Your Ref: OWPC19792
Our Ref: EP/100/18/PL 24-06-2018
Please ask for:
Zac Denton

Conservatory to rear elevation.
6 Langmeads Close East Preston

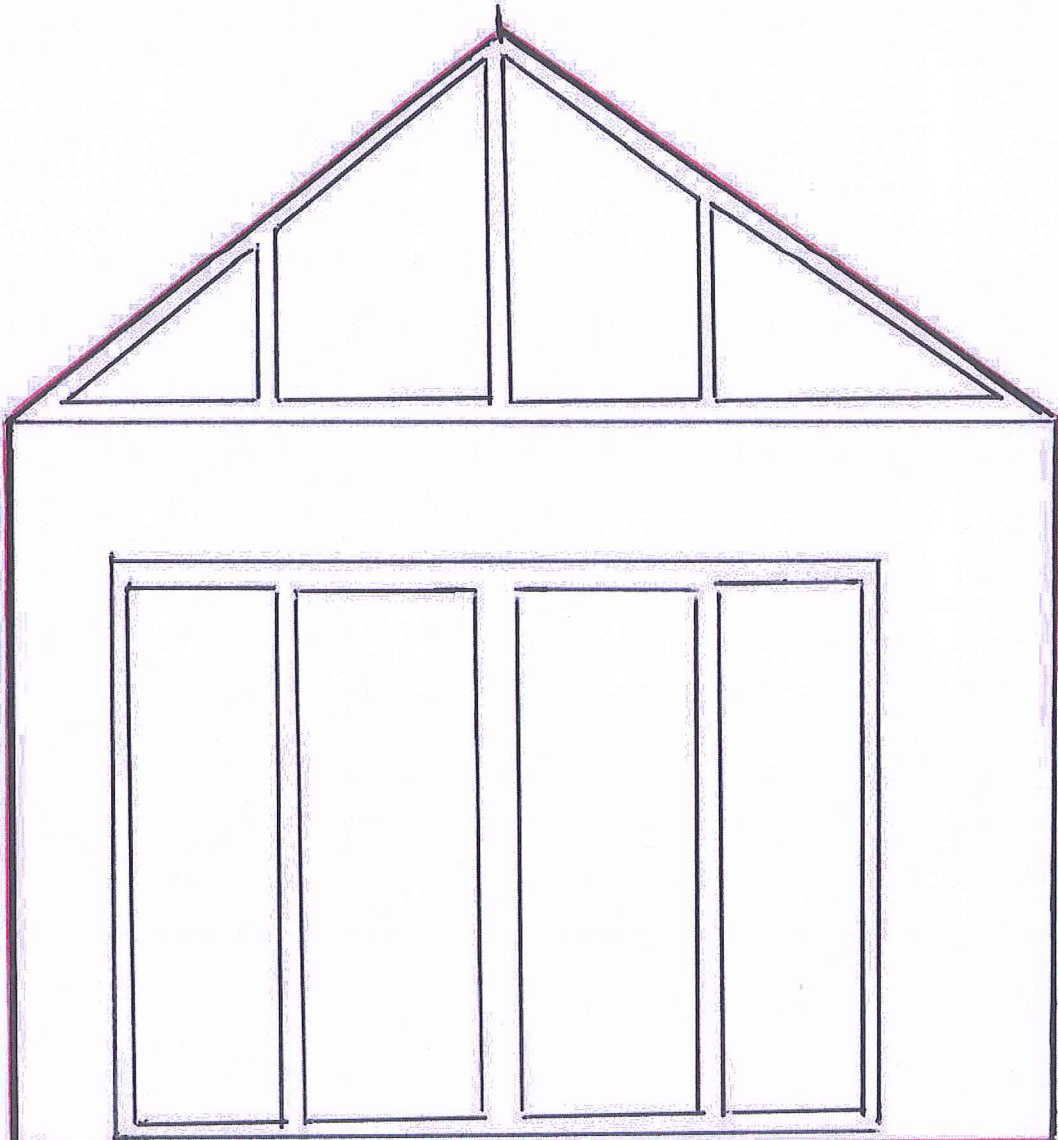
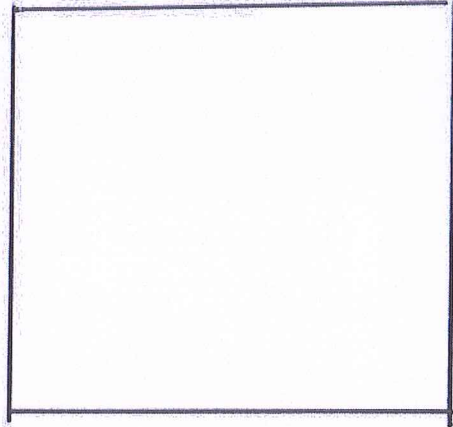
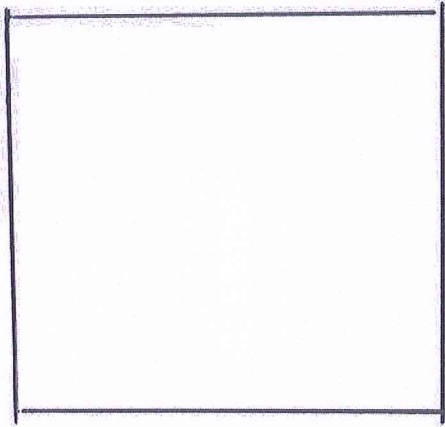
5 Langmeads Close is situated adjacent to the North of 6 Langmeads Close. Being owner occupiers we have concerns, which we have discussed with Mr & Mrs Burke, affecting our living room and patio privacy which the fan light windows / openings to the North elevation of the proposed conservatory would invade.

The conservatory floor level would be level with the living room and thus higher than the existing patio level. Combined with the close boundary proximity of the North elevation the fan light windows / openings would allow a direct line of sight into our living room and onto our patio. This would be an invasion of our privacy and affect our lifestyle substantially.

Mr & Mrs Burke are appreciative of our concerns and have said they are agreeable to the North elevation being entirely brick to roof height without windows / openings. This amendment would retain our current level of privacy and resolve our concerns.
